Your Ref: OWQC21193
Our Ref: EP/182/18/PL
Please ask for:
Mr A Wood

1 No. end of terrace house together with associated car parking, new vehicular access, garden shed & planting (resubmission following EP/148/17/PL).

20 Lashmar Road East Preston

Thank you for your internet comments made on 22nd January 2019 which has been recorded as **'no objection'** with the comments as follows:

SITE PLAN

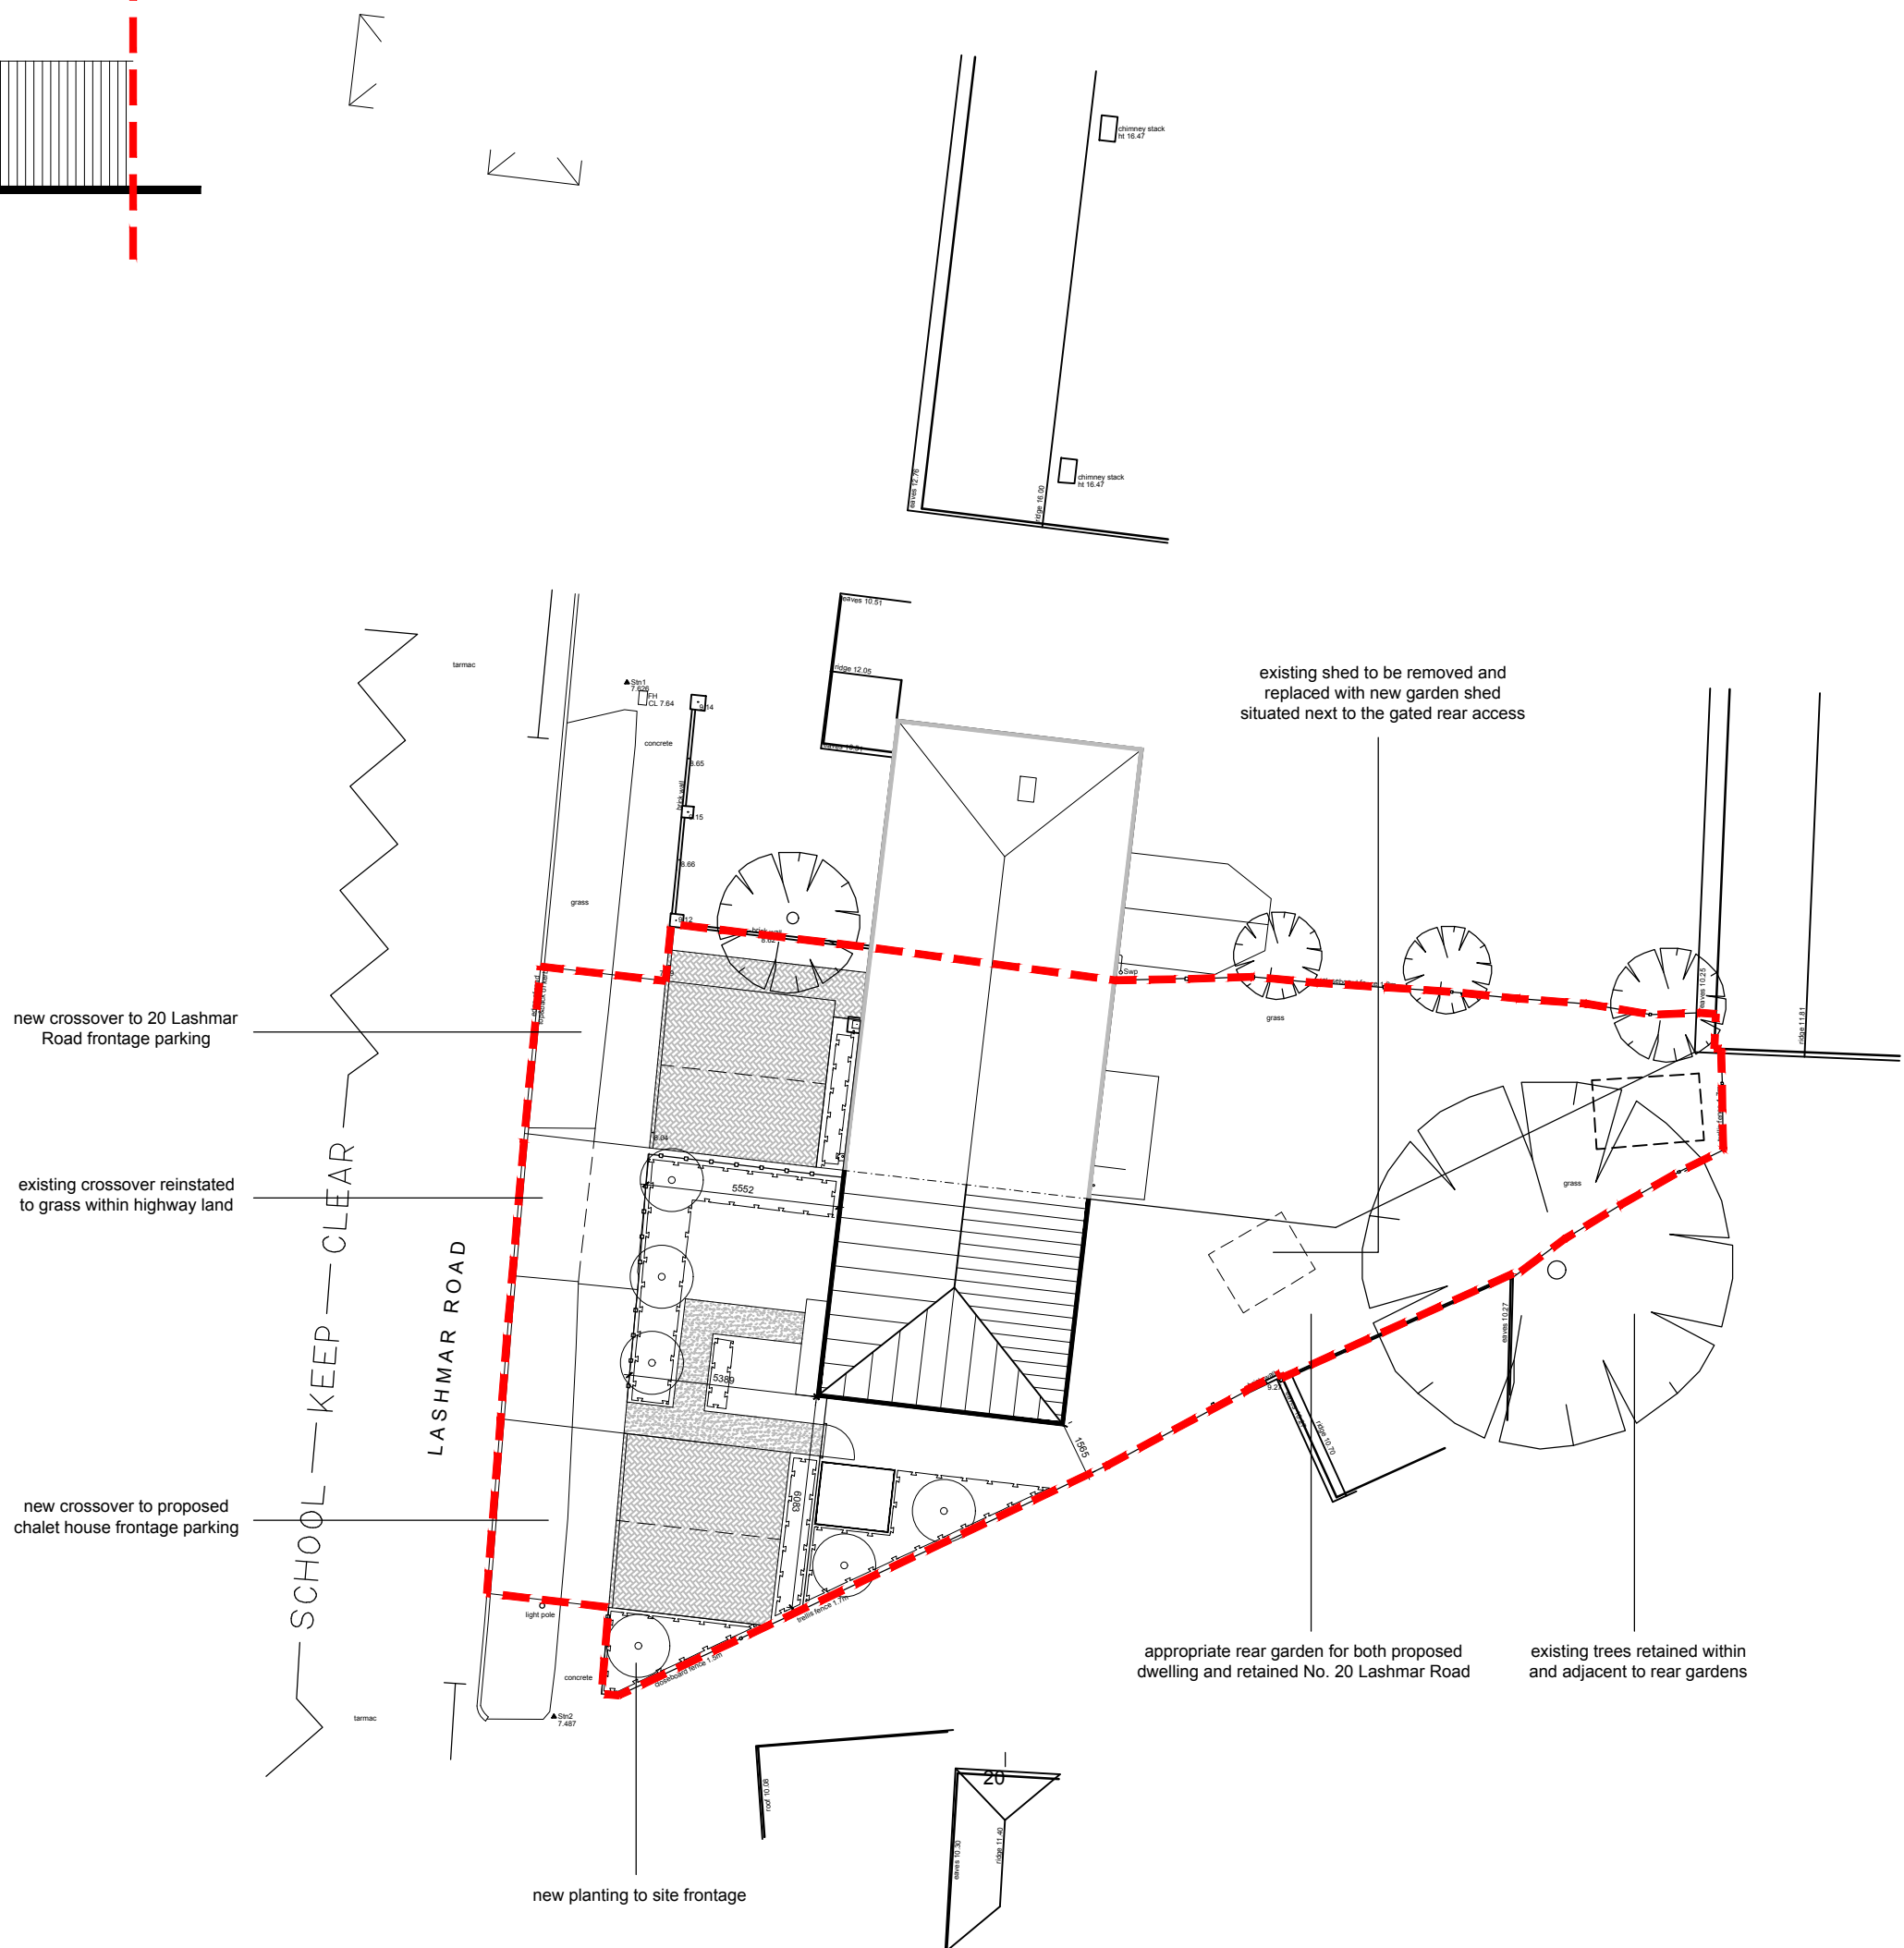
The East Preston & Kingston Preservation Society has no objections to this Application but asked this council to advise ADC of a sewer pipe apparently running underneath the site of the proposed new building.
